Date: 24-Mar-2026
Our Ref: 2026/90270

**TOWN AND COUNTRY PLANNING ACT 1990
TOWN AND COUNTRY PLANNING (GENERAL PERMITTED DEVELOPMENT)
(ENGLAND) ORDER 2015, ARTICLE 3, SCHEDULE 2, PART 14, CLASS J
NOTIFICATION OF PROPOSED DEVELOPMENT
APPLICATION NUMBER: 2026/90270
AT: Scissett Mount Nursing Home, Busker Lane, Scissett, Huddersfield, HD8
9JU**

Prior approval for installation of solar photovoltaic (PV) panels and associated works

Project:	Busker Lane, Scissett
Client:	TLC Care Group
Title:	Existing and Proposed Roof Plans
Date:	13.01.26
Drawn:	RM
Check:	DB
Scale@A1:	1:200
Revision:	P01
Status:	Planning

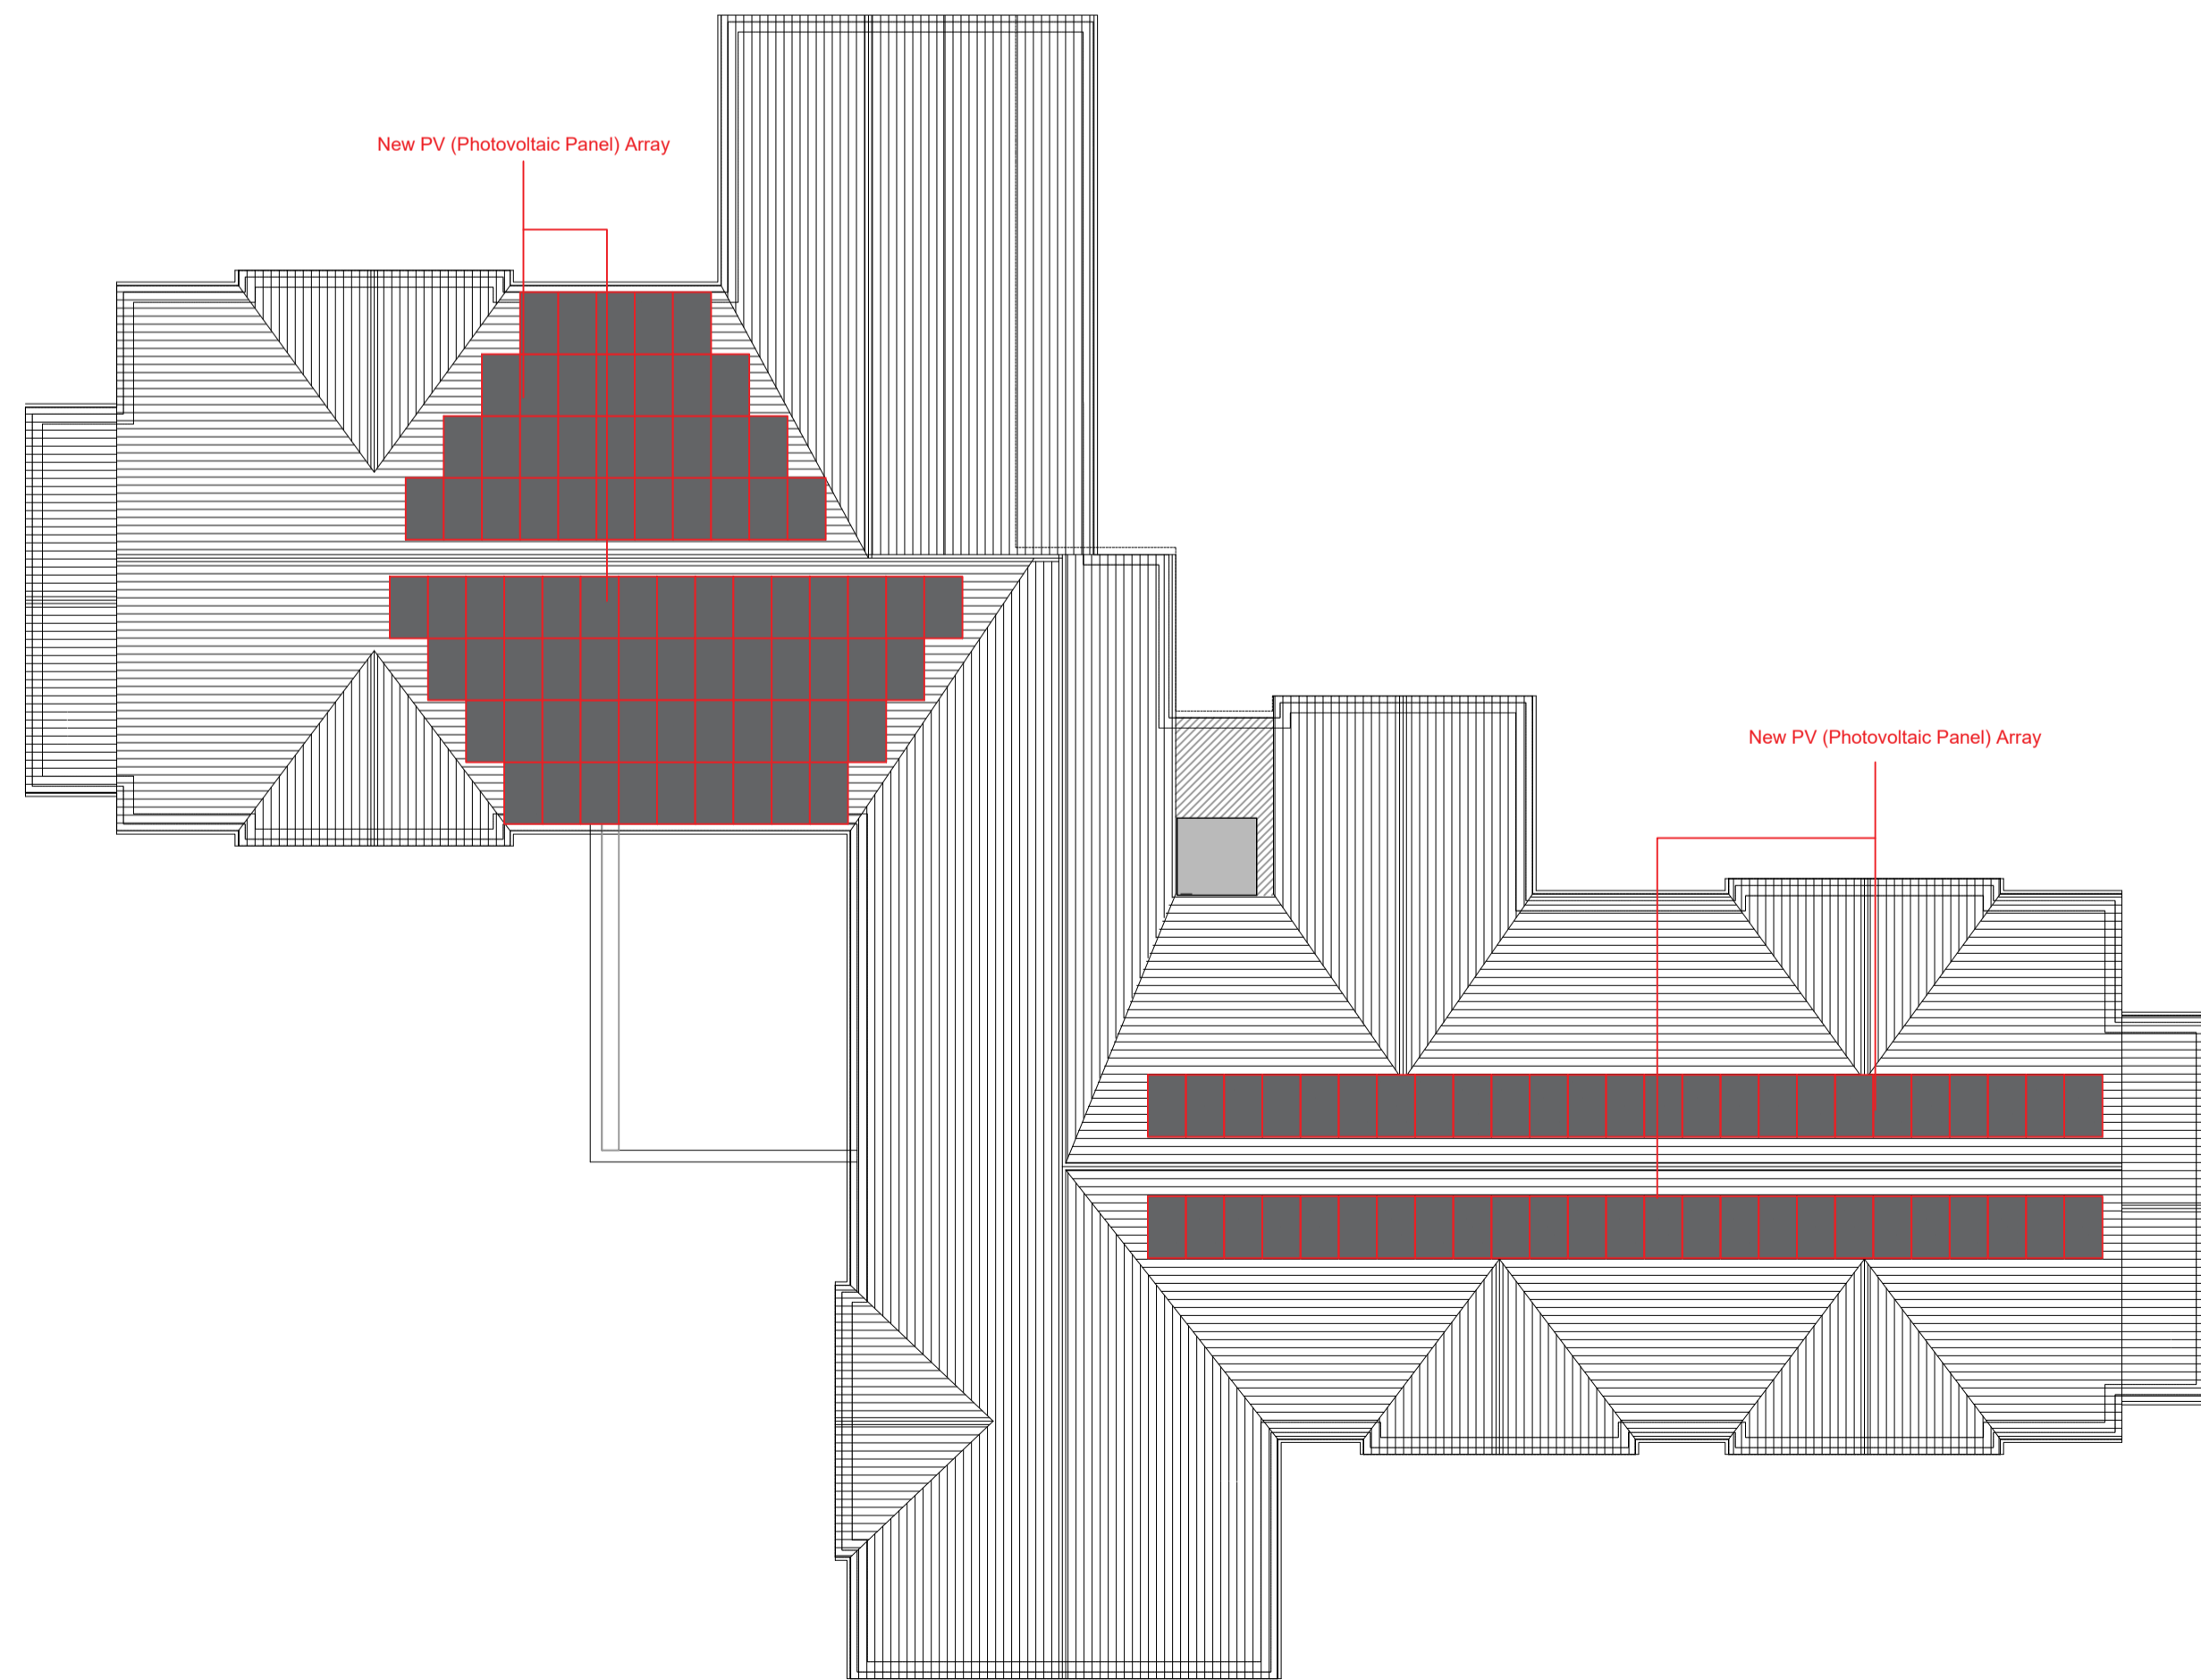
1. The installation of solar PV equipment is not considered to benefit from a general planning permission under Article 3(1) and Part 14, Class J of Schedule 2 of the Town and Country Planning (General Permitted Development)(England) Order 2015 (as amended) as the solar panels as shown on submitted plans would be installed within 1 metre of the external edge of that roof.
